Re: Falcon Marketplace Early Grading Permit (SP-17-001/CDR-16-007) Response 5

Please accept this response letter to your review 4 comments dated July 21, 2018.

Preliminary Drainage Report (PDR) / Drainage Plans

ED-1

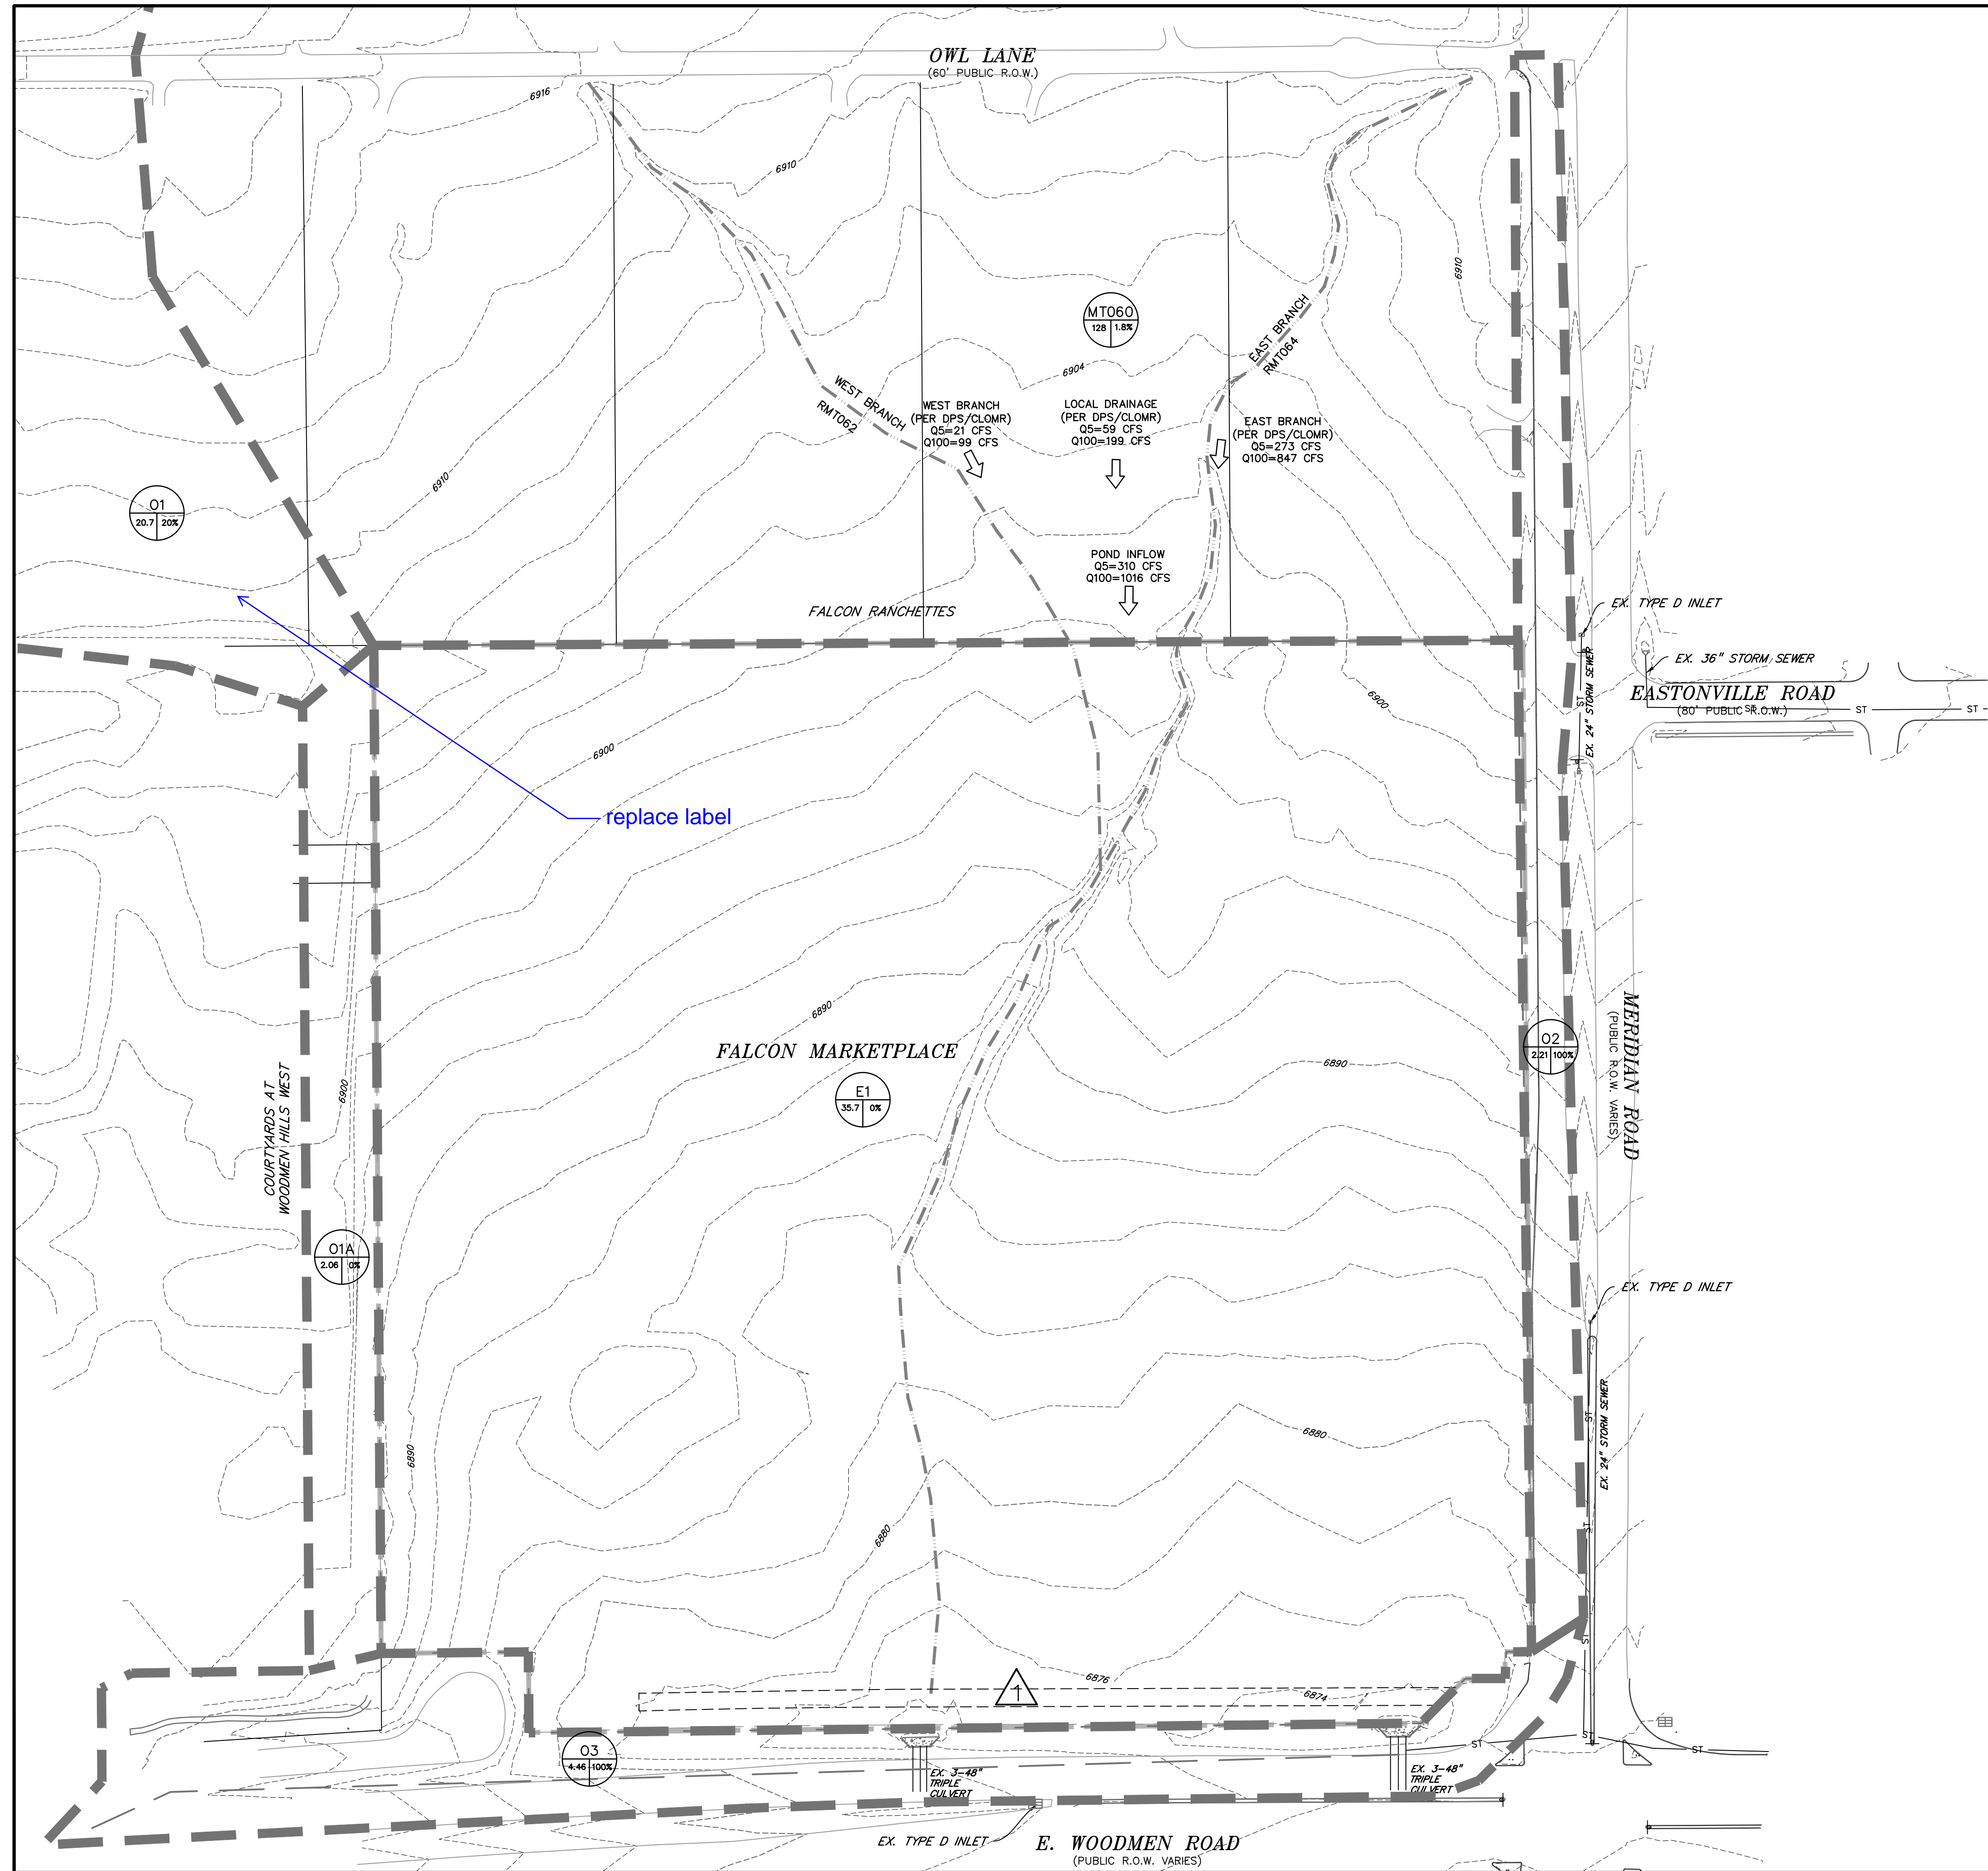
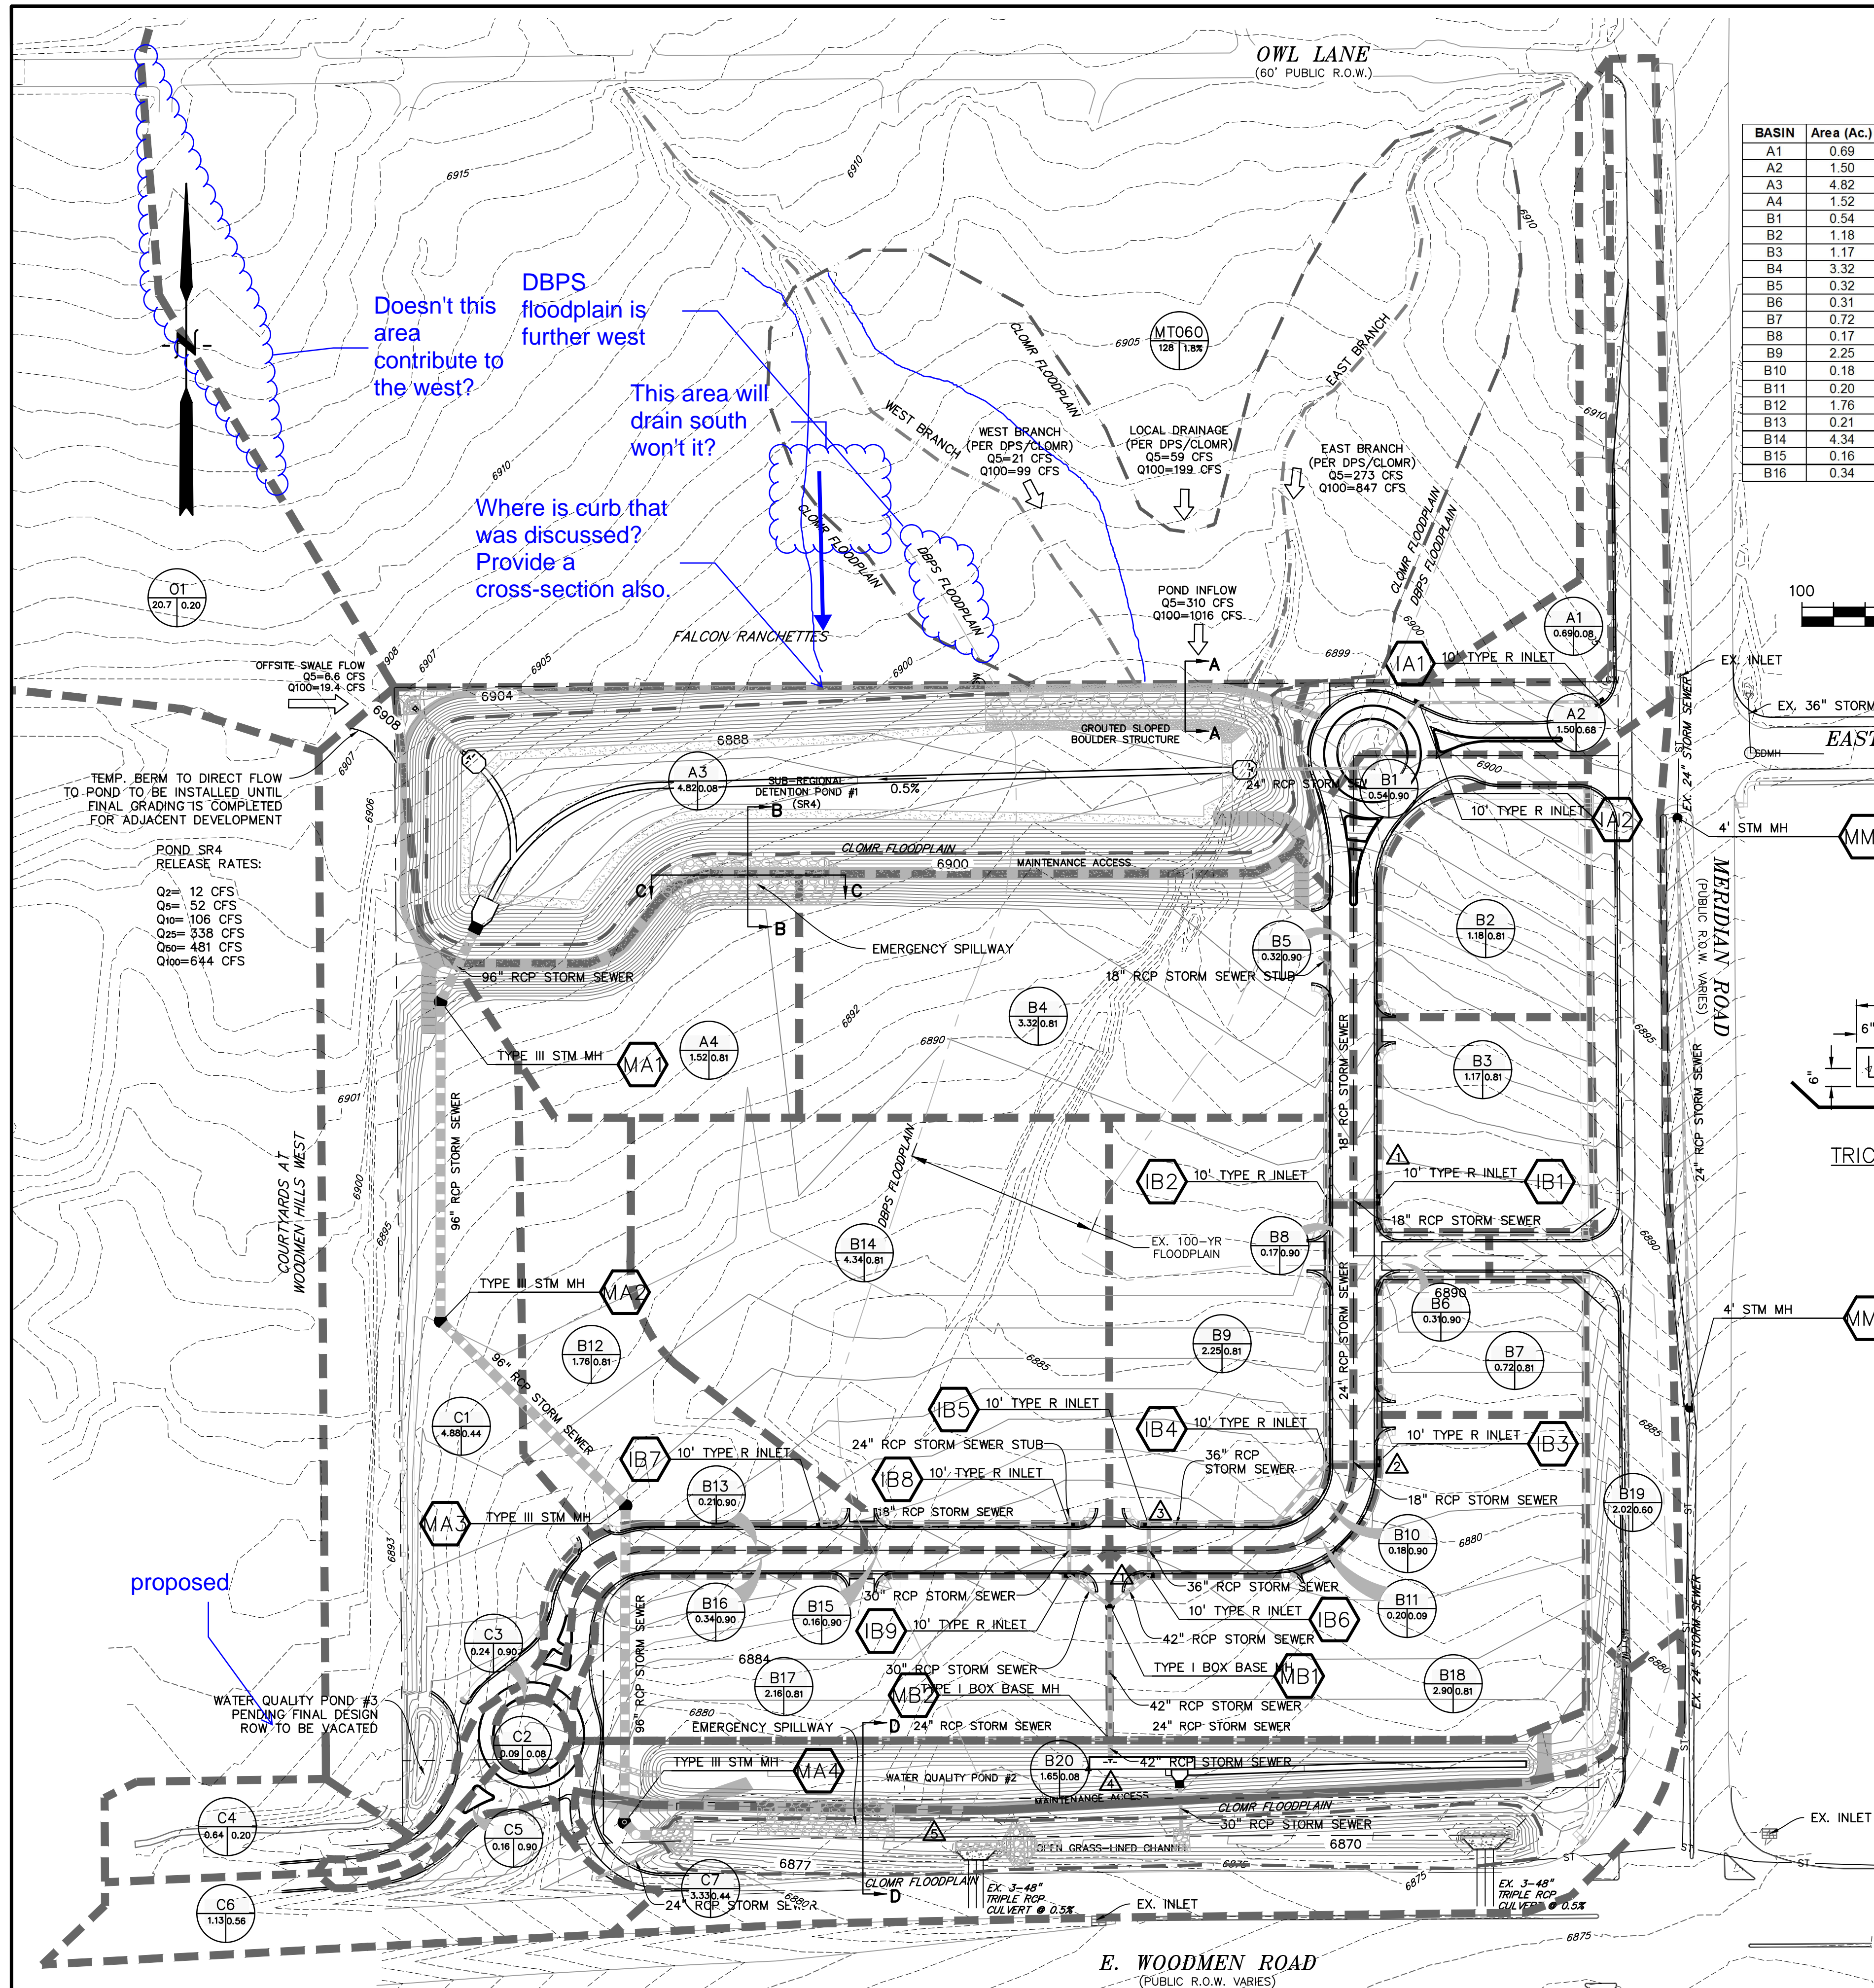
- c. *Resolved*
 - d. Provide a design point summary of 5- and 100-year flow rates at all surface and pipe design points on both the existing and proposed plans. Partially resolved; address per local basin and DP redlines. *Comment remains; see redlines regarding flows from the north. Comment remains.* Unresolved. **Flows from the north clarified and broken out into the separate reaches.**

**C7.2**

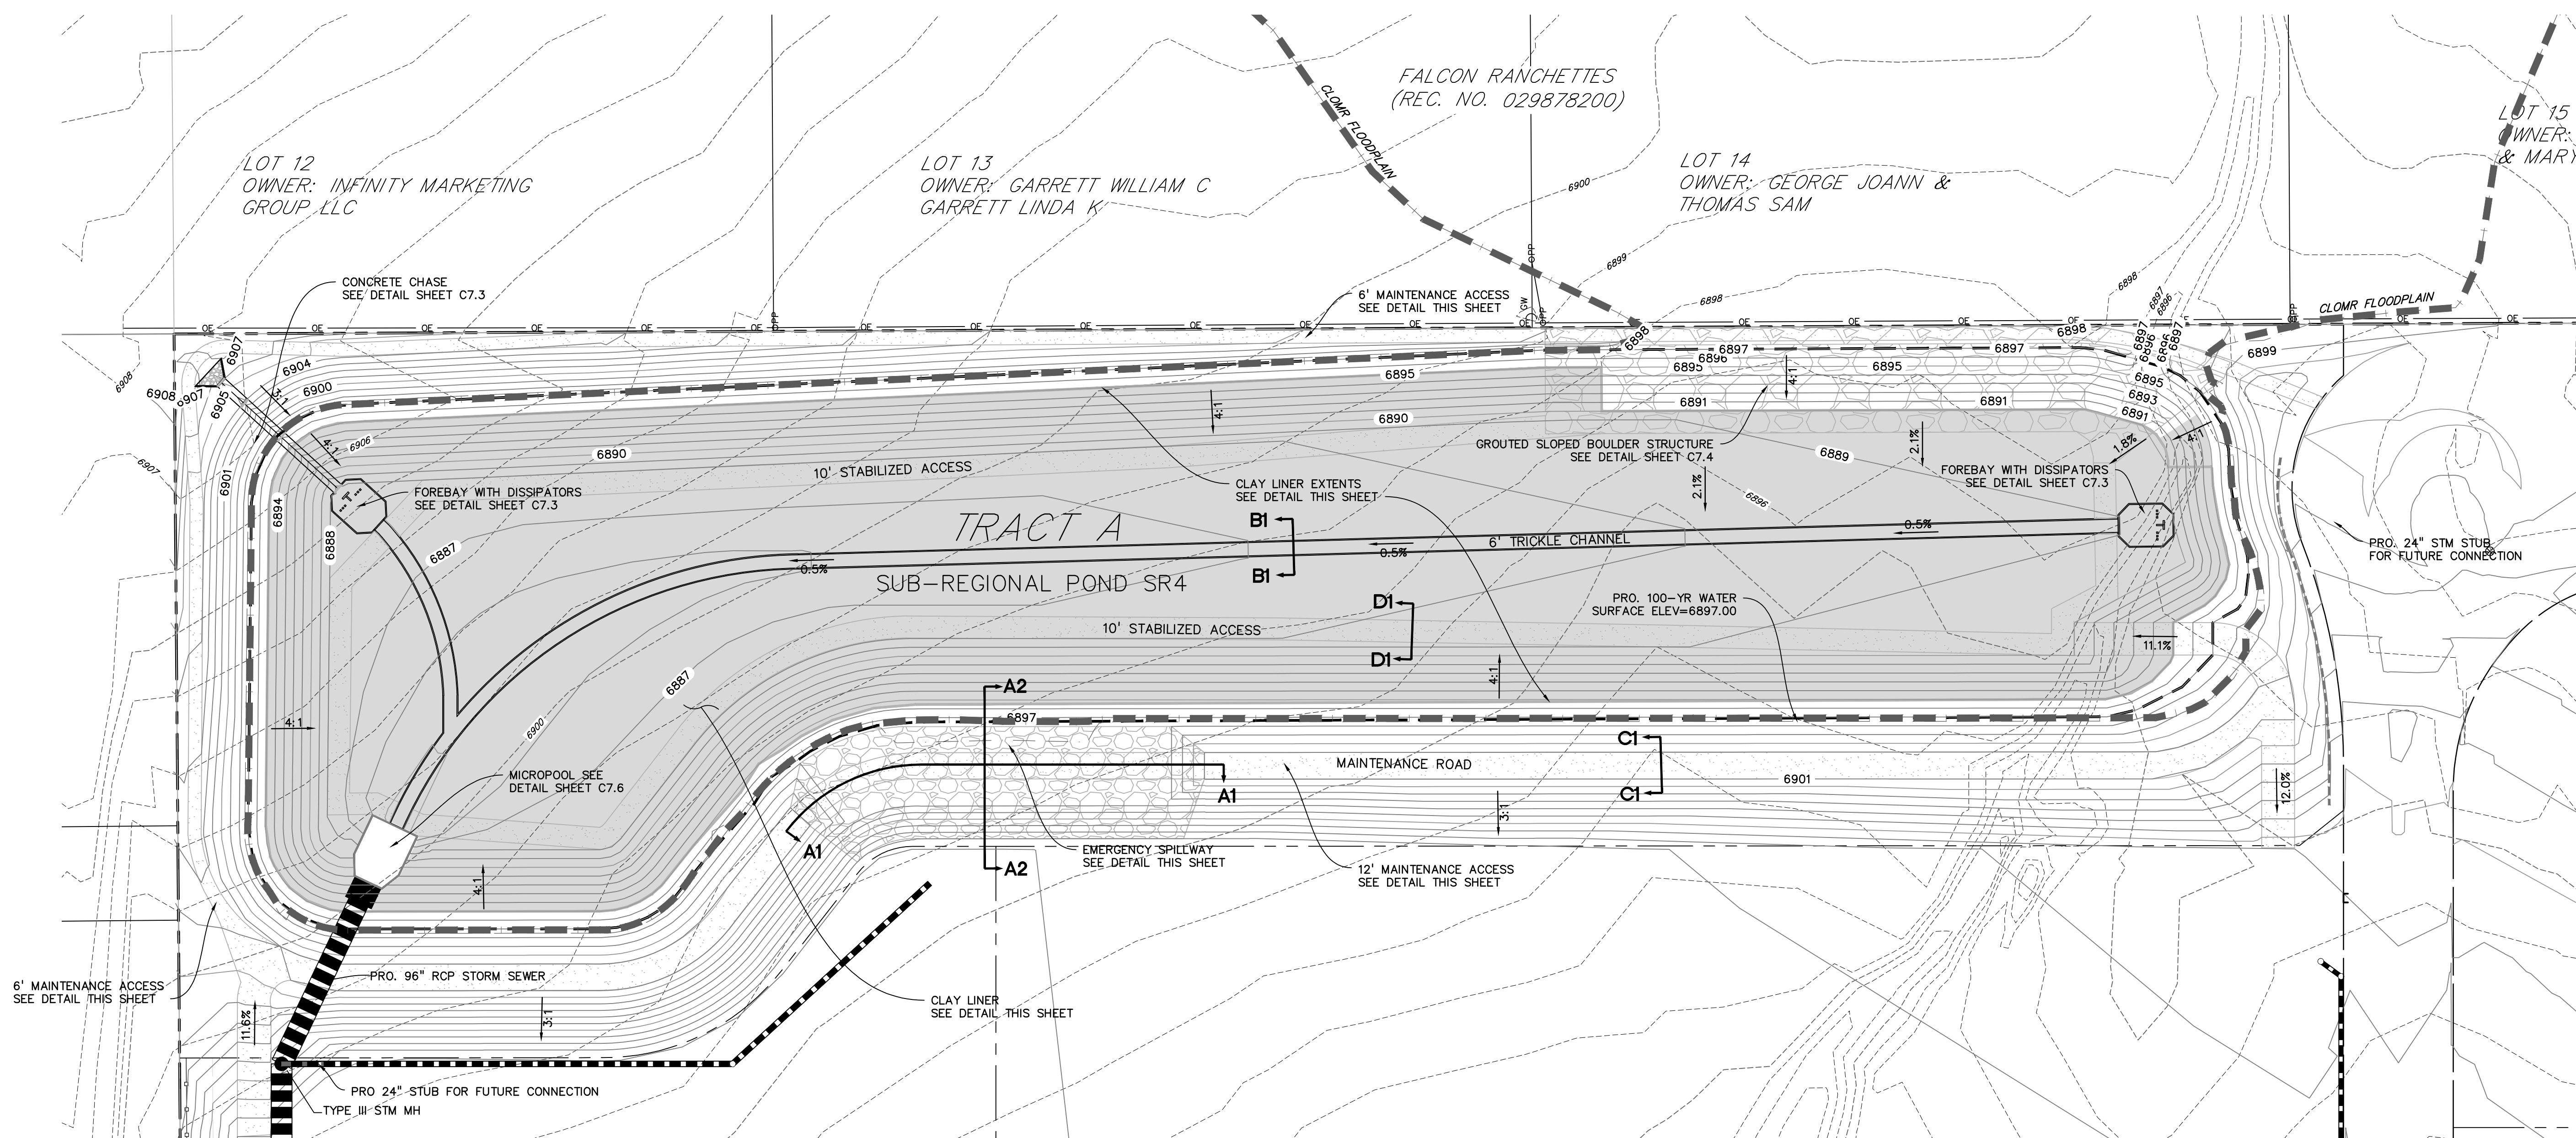
- a. Resolved.
 - b. Show and label all proposed maintenance access roads and easements on the Developed Conditions Plan. Partially resolved; see GEC redlines regarding this. Provide stabilized access roads along the west and north sides of the pond. See *additional redlines; due to the rundown along the north side of the pond, pond bottom stabilization is required which could be incorporated into an access road design through that area. Comment remains.* Partially resolved; details need to be provided in CDs. **Further details added to the plan set.**
